From: Moir, Douglas [Douglas.Moir@lancashire.gov.uk]
Sent: 30 April 2013 10:48
To: Jane Tucker
Subject: Higher Standen Hey (3/2012/0942)

Figure 4: Geophysical Interpretation

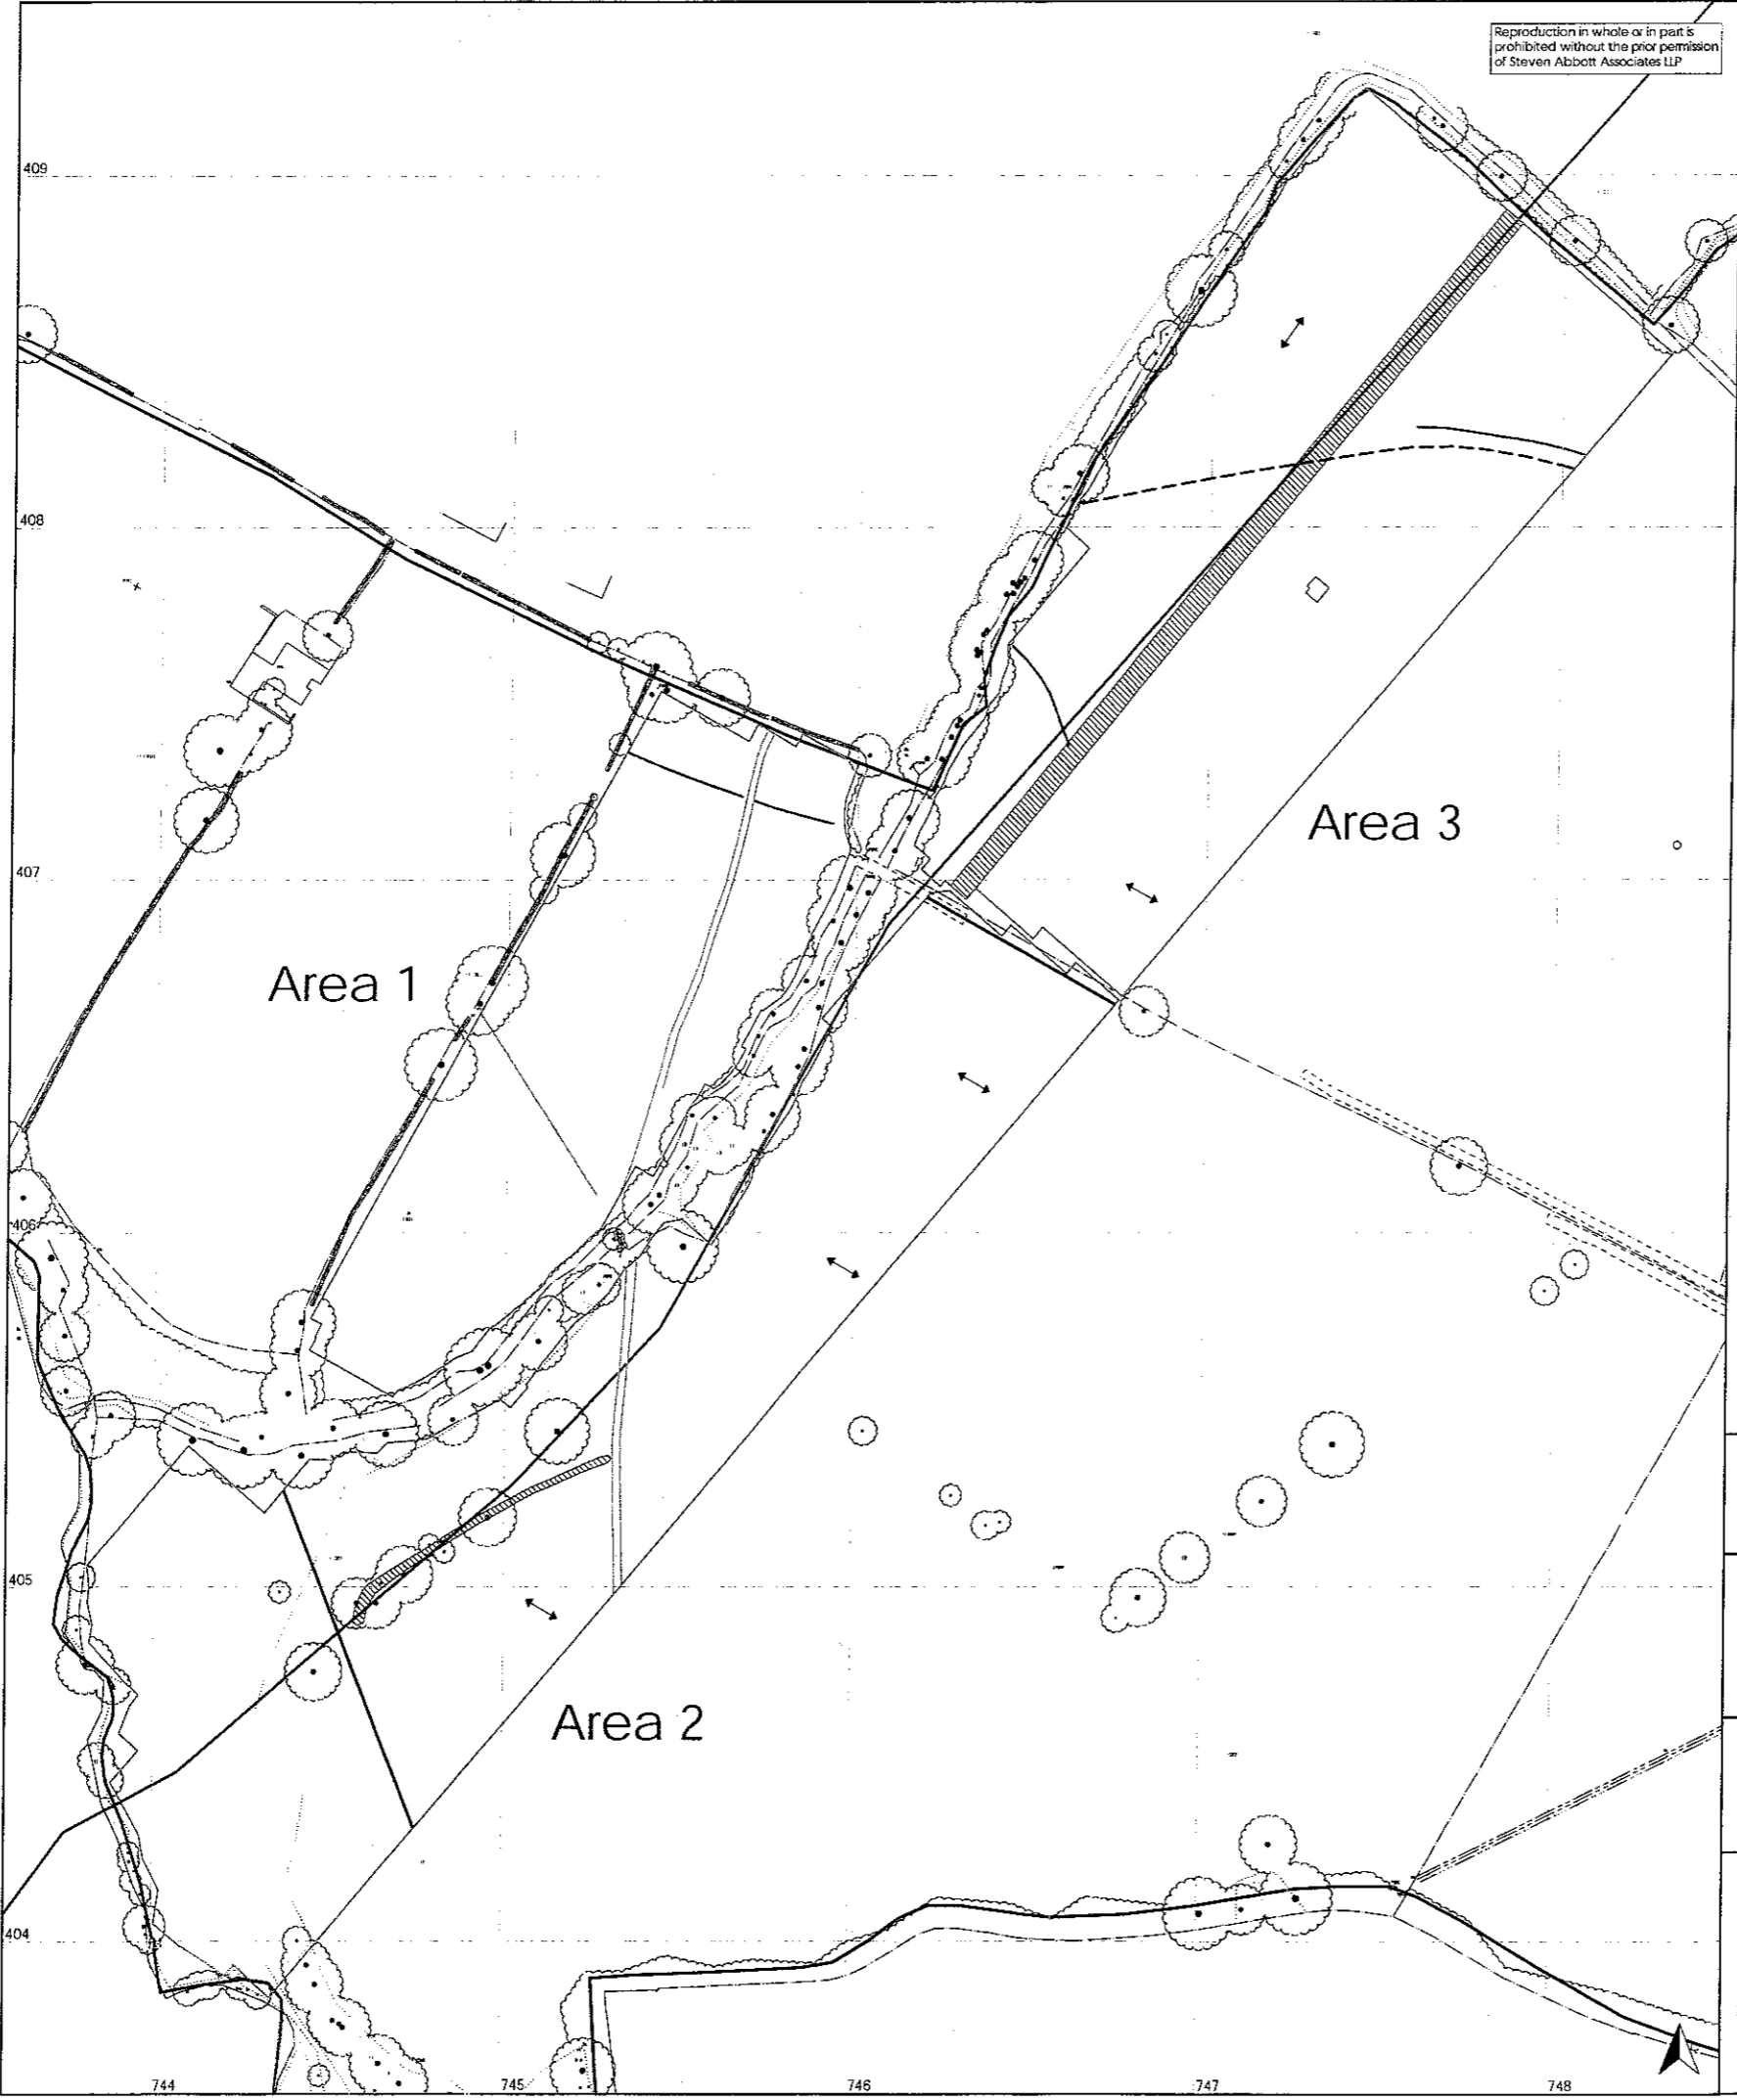
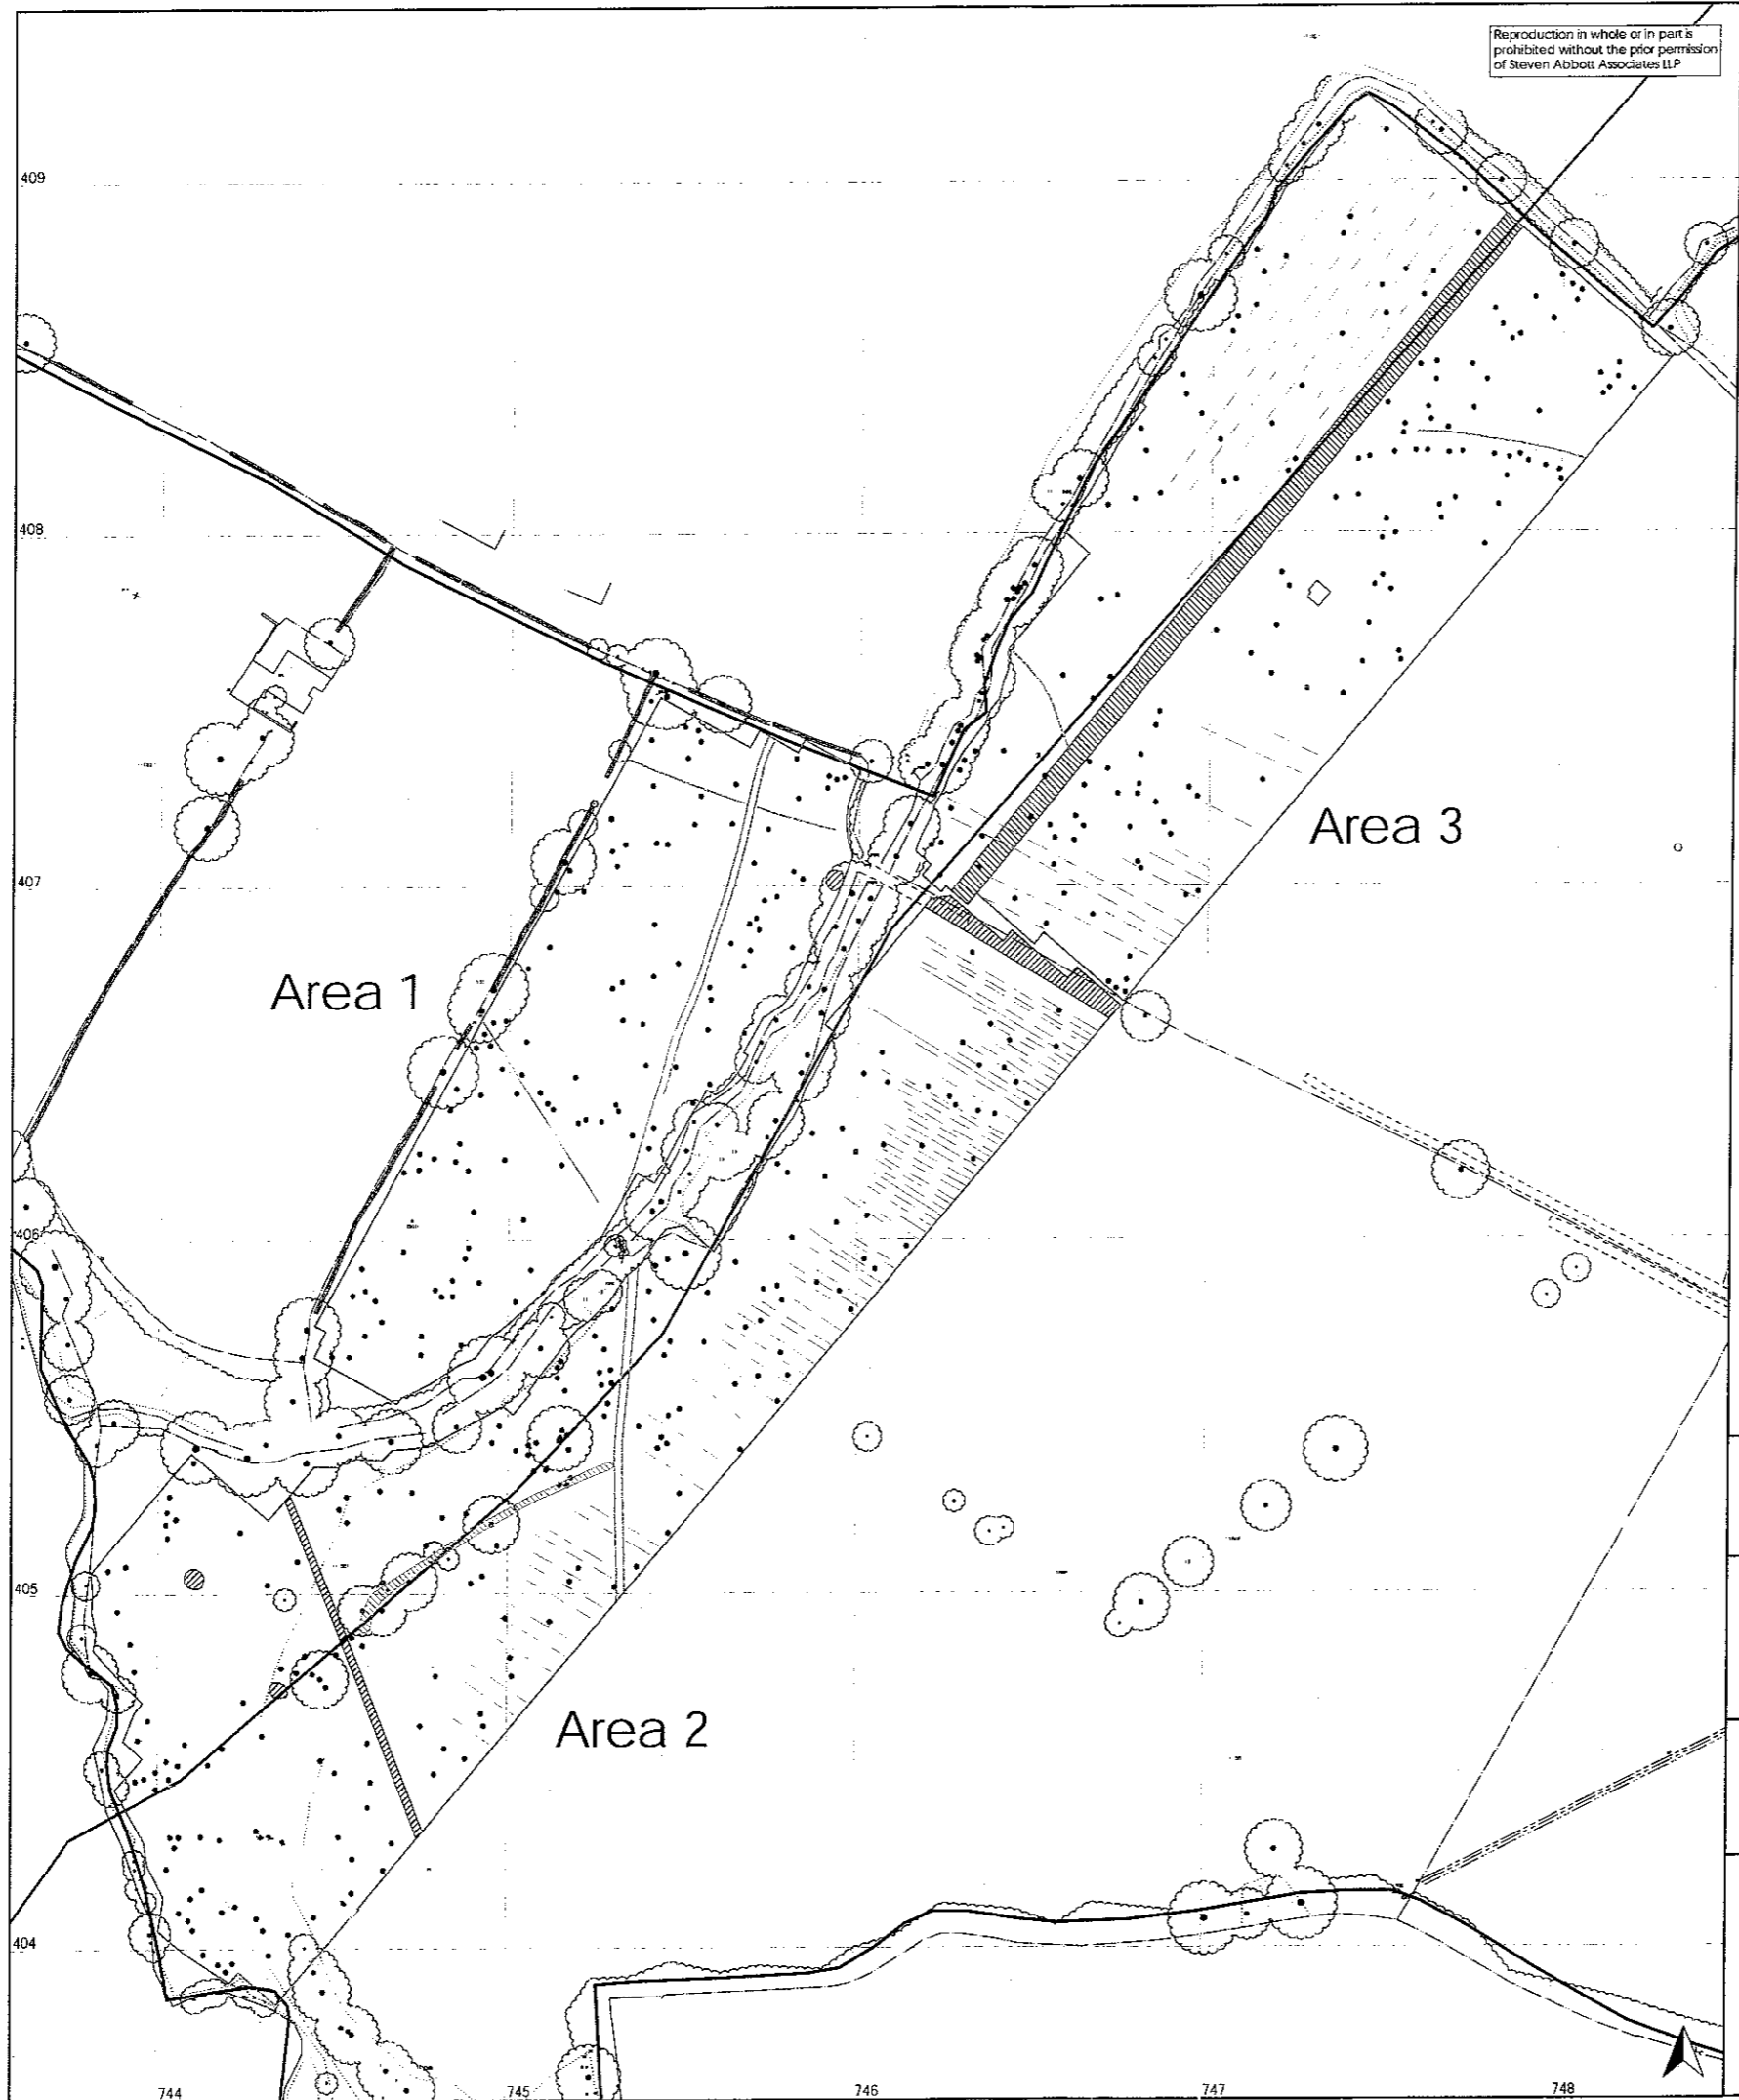
The results of the geophysical surveys (Jan & Aug 2012) has demonstrated that there are surviving below-ground and upstanding remains of the Roman road recorded as crossing the site. In addition to these remains, the surveys have also encountered potential evidence for other archaeological features on the site, and which will therefore need to be subject to further archaeological investigation.

As has been previously recommended, the upstanding earthwork remains of the Roman road will require recording in the form of a topographical survey, and this area should therefore be removed from the development so as to enable the road to be preserved in situ. Where the line of the Roman road is known to survive as a below-ground feature, it will, where it is affected by the proposed development, need to be excavated and recorded.

As to the other previously unknown features of potential archaeological interest, they will need to be the subject of further archaeological investigation to determine their significance and the potential of the site to contain other features of archaeological interest that have not been picked up by the geophysical survey.

Such works will therefore need to form part of a staged programme of archaeological investigation; topographical survey, evaluation of the Roman road and geophysical anomalies and depending on the results of the evaluation possibly a wider area of the site in order to ensure that 'blank' areas in the geophysical survey are really devoid of archaeological interest, open-area excavation of areas identified by the evaluation as being of archaeological interest. A few standing buildings have been identified as being of historic interest, and they shall need to be recorded prior to any proposed conversion or demolition.

Condition: No development shall take place on the site until the applicant, or their agent or successors in title, has secured the implementation of a programme of archaeological work. This must be carried out in accordance with a written scheme of investigation, which shall first have been submitted to and agreed in writing by the Local Planning Authority.
